1 November 2012

(Your Ref: MP10_0177 MOD 12)

**Re: COUNCIL SUBMISSION TO MP10_0177 MOD 12, APPLICATION TO
AMEND THE PROJECT APPROVAL**

THIRD FLOOR
SCALE 1:200

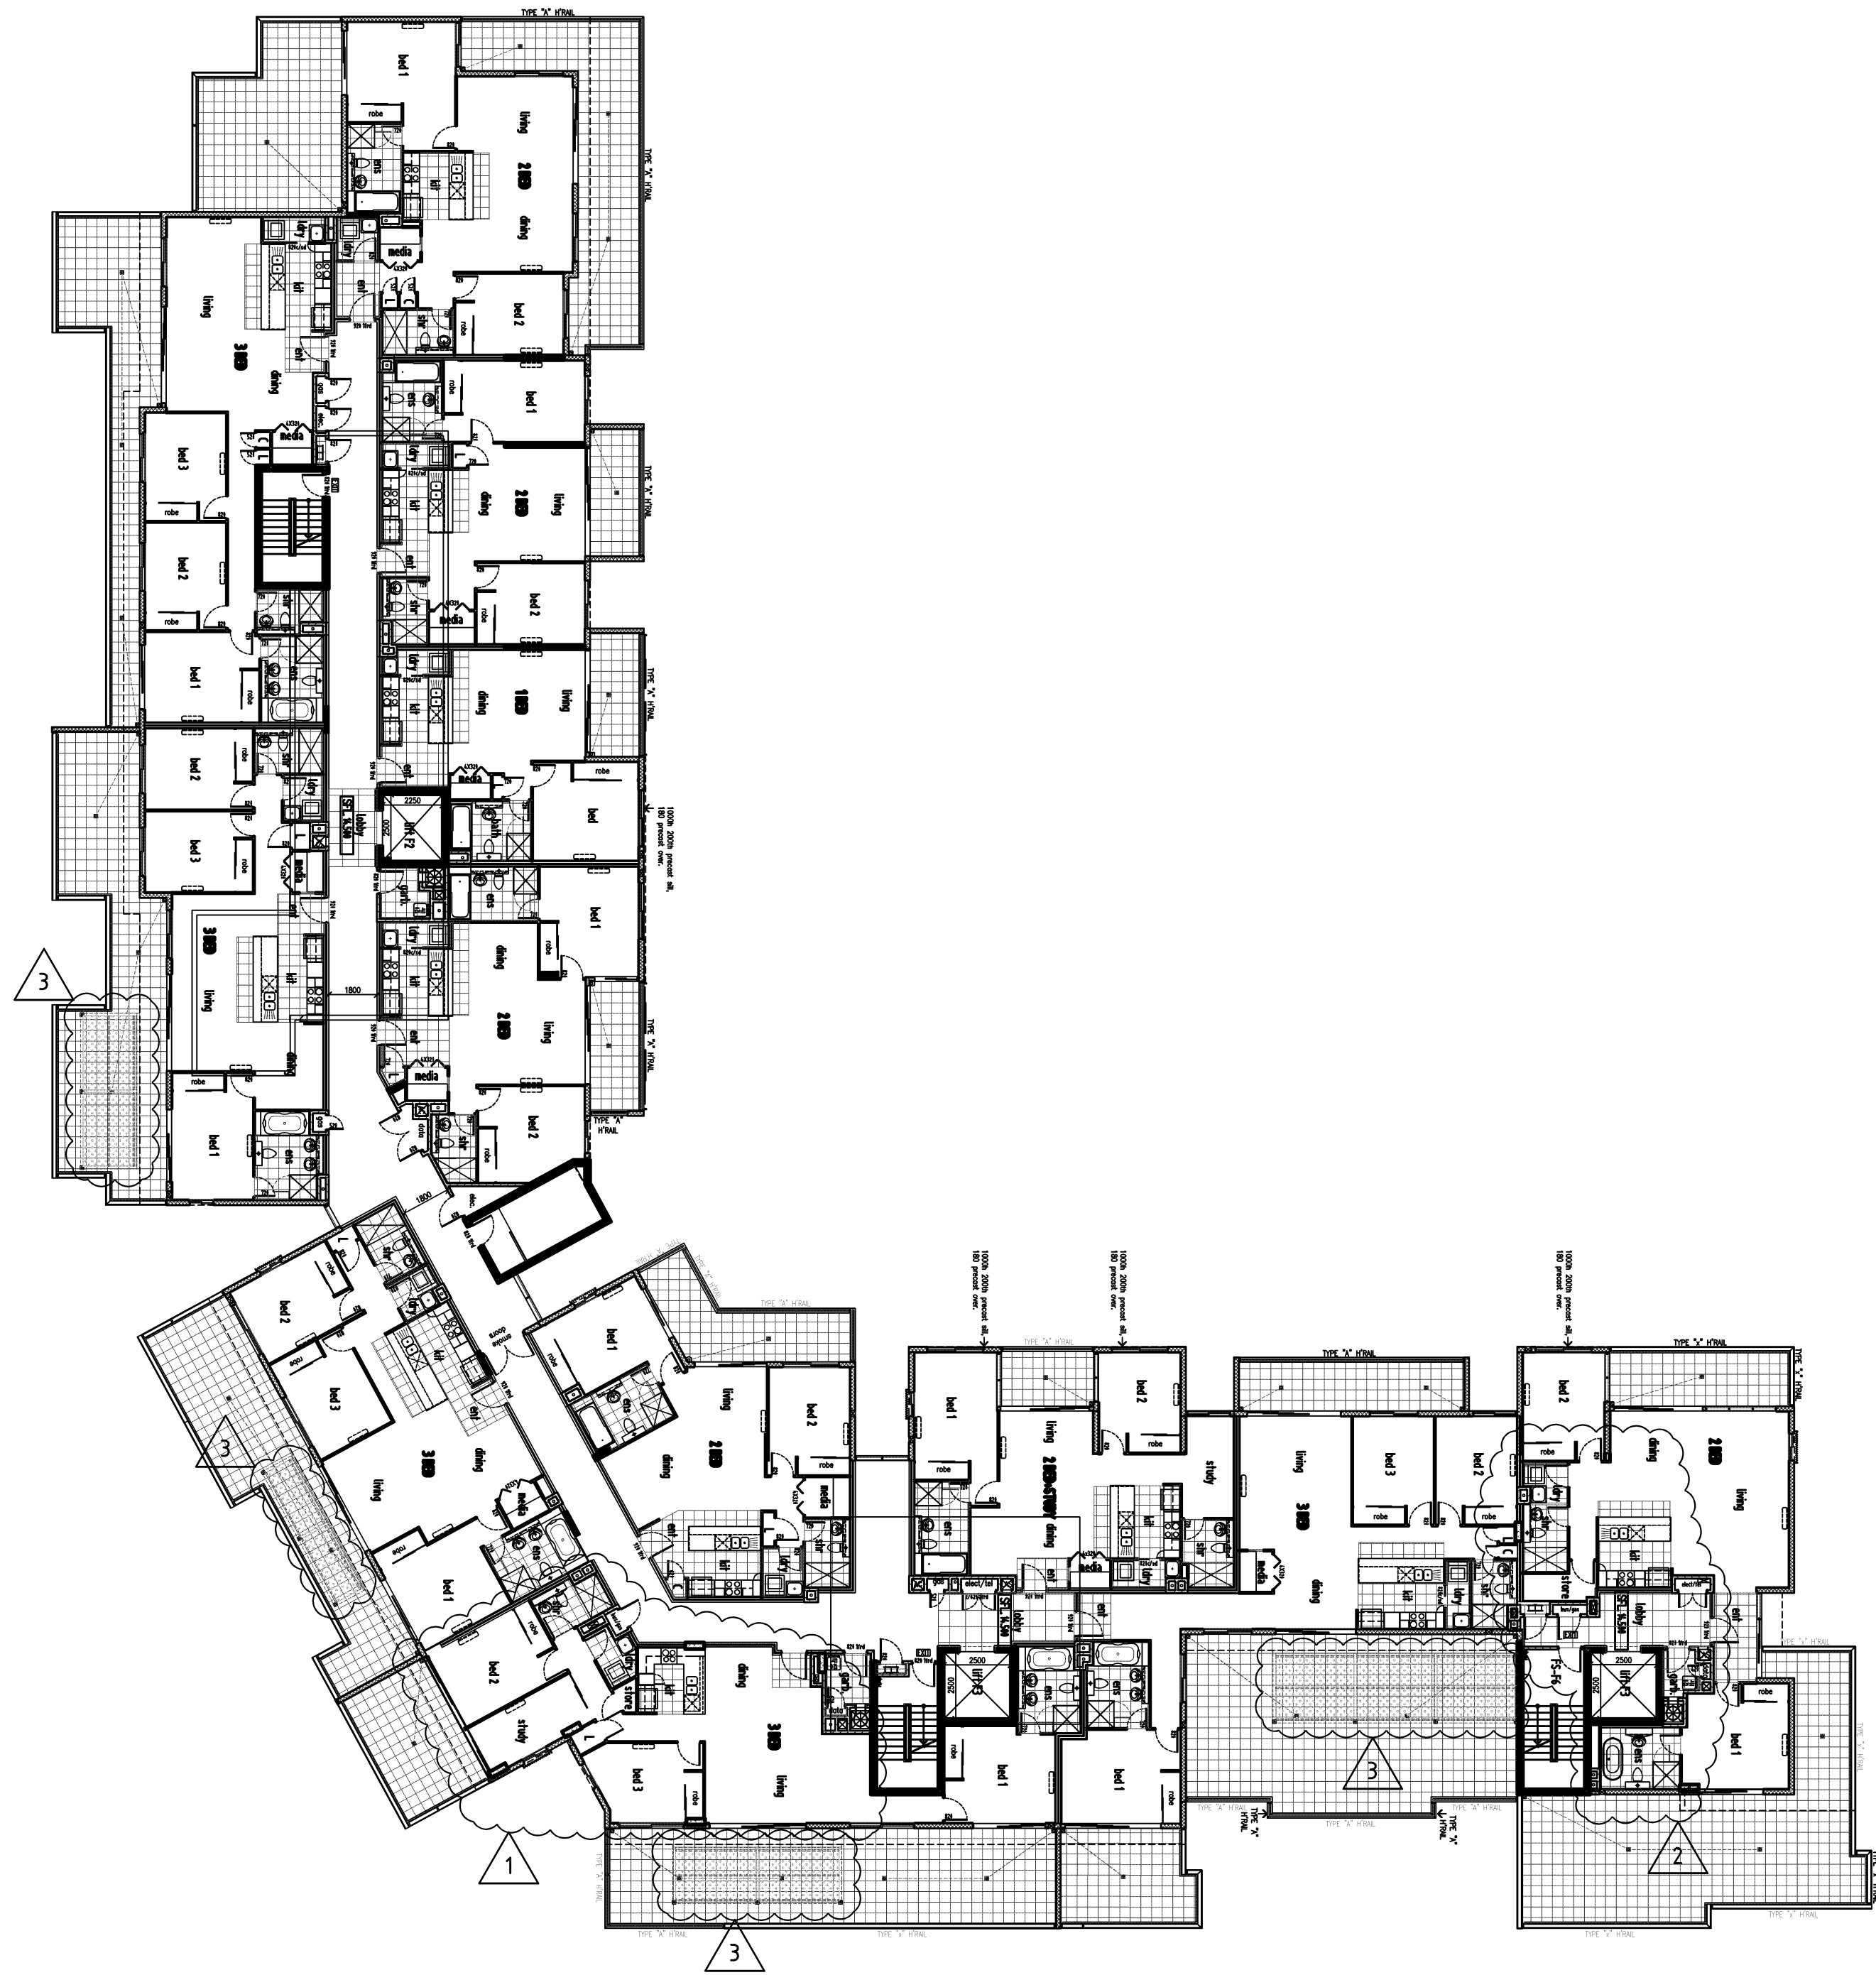
No objection is raised by Council to this modification application provided the Department of Planning & Infrastructure is confident the reconfiguration of dwellings and other changes will not affect car parking requirements or deep soil planting calculations.
